COL JAMES

Student Accommodation

Precinct 3 - Pemulwuy

Evolution and refinements through the Design Review Panel process and recommendation

ENTRY LEVEL PLAN

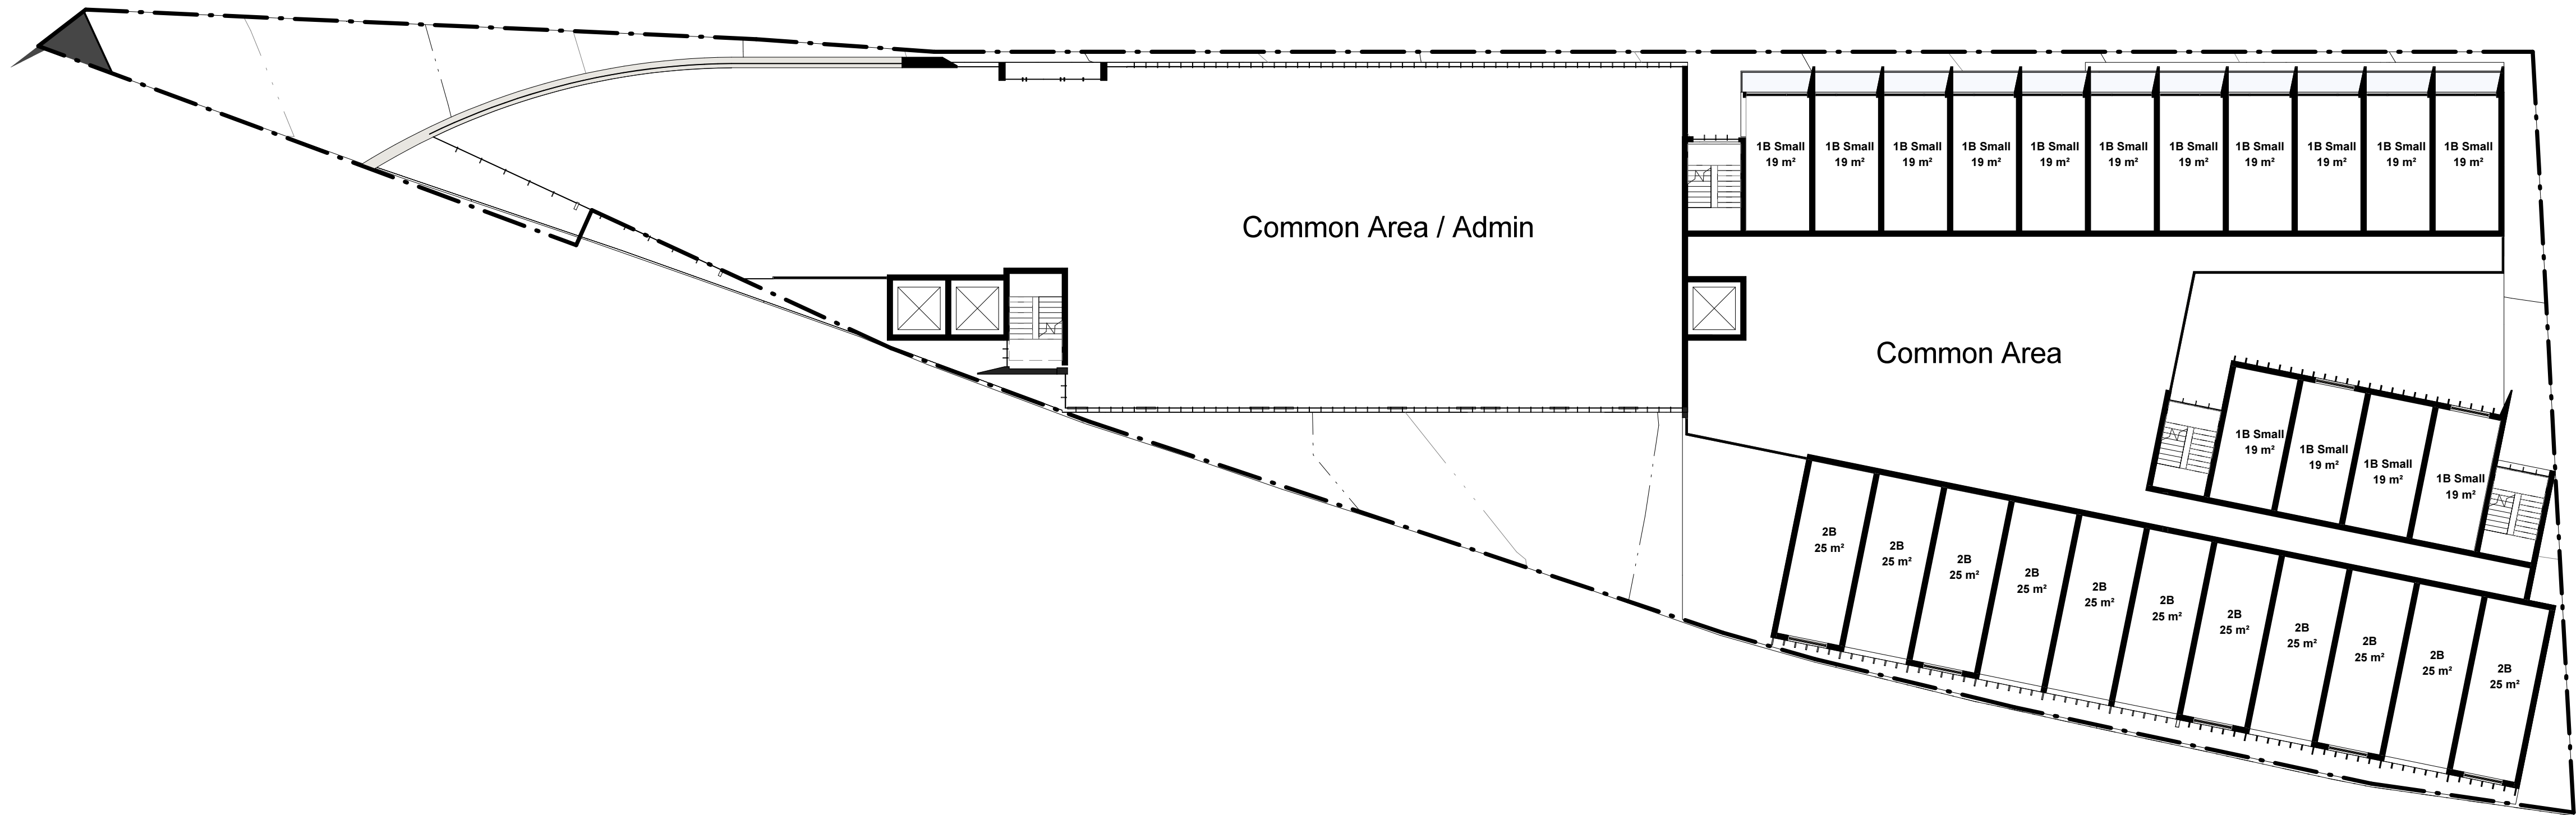
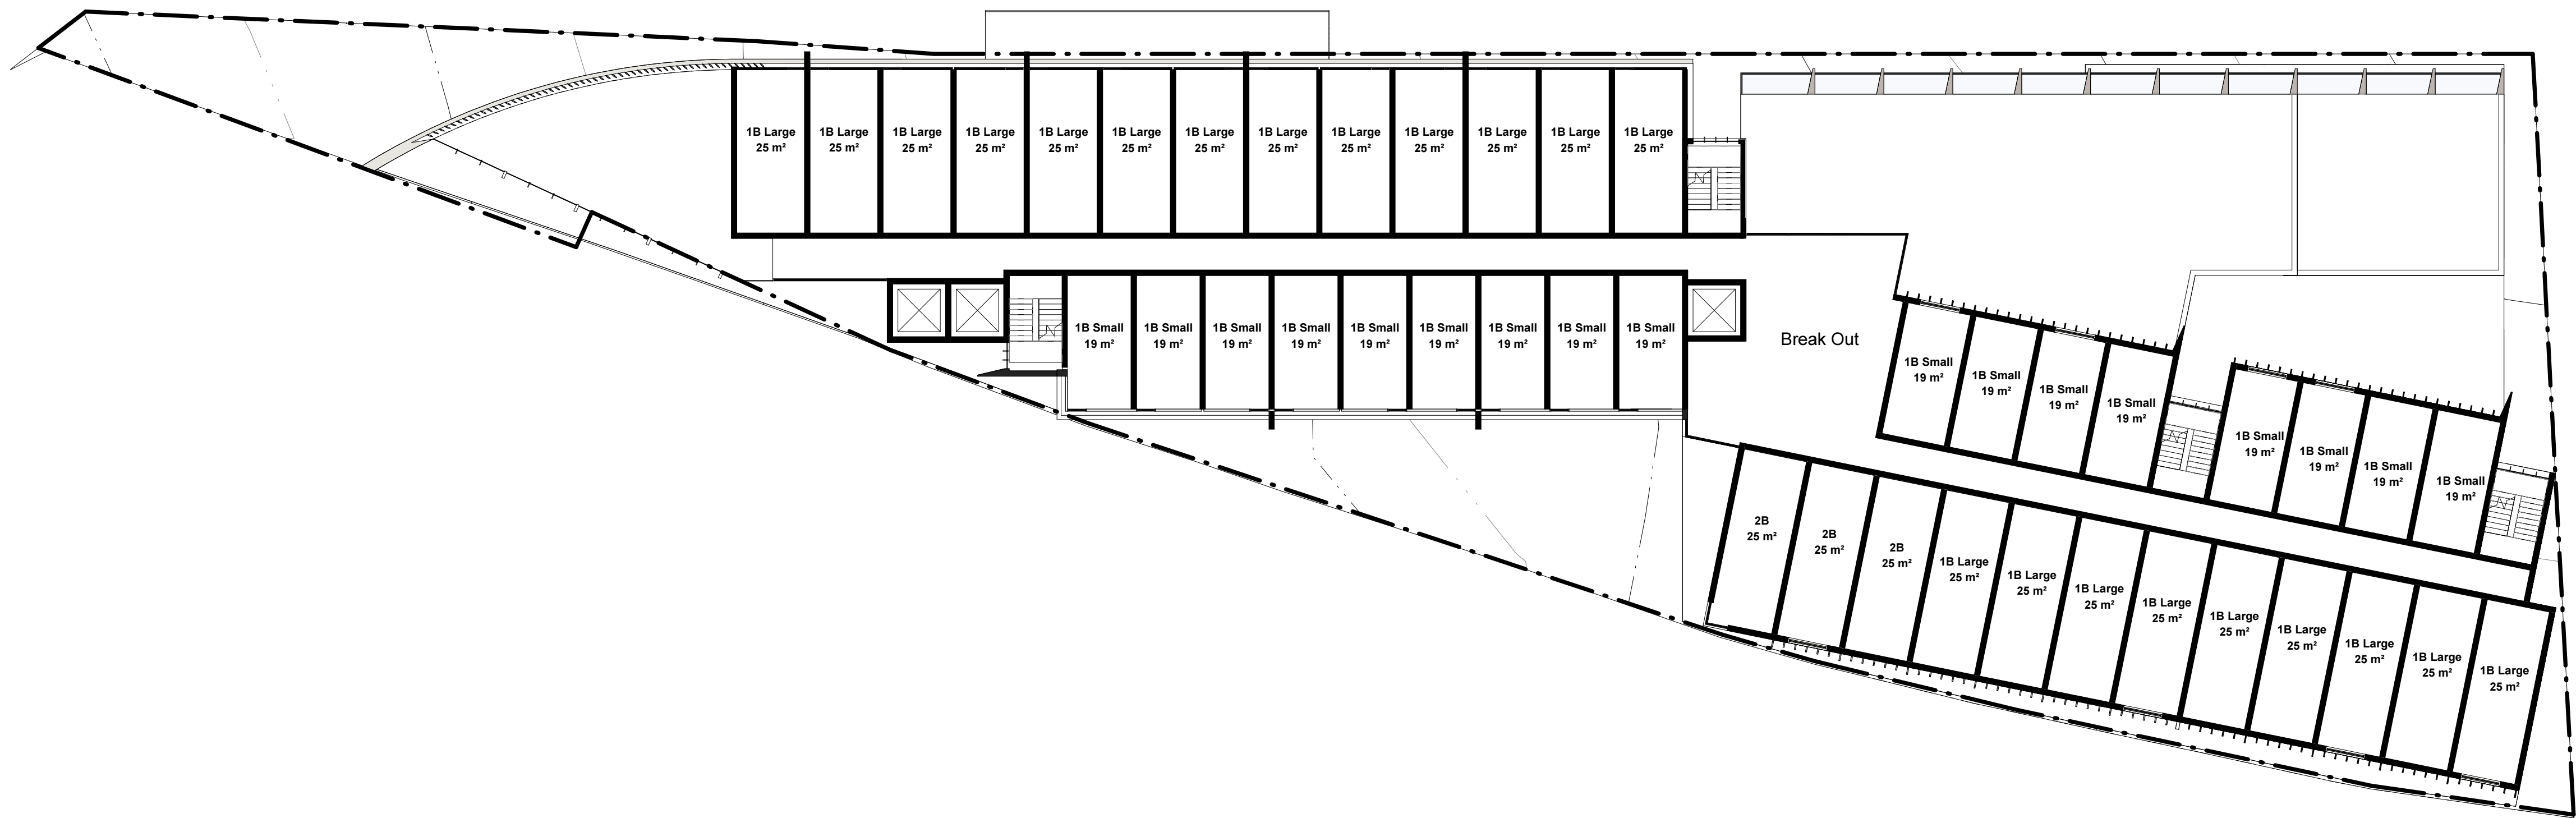
2.4.13	<p>Various options were discussed for locating these spaces. For the typical floor communal areas it was agreed that the space should be positioned at the south end of the courtyard, as this is close to the lifts and will assist in resolving proximity issues with individual living units in this part of the floor plan. One option was to swap two end living units to the east façade, to allow the communal area to occupy the end of the courtyard with excellent access to view, light and ventilation.</p>	Noted.
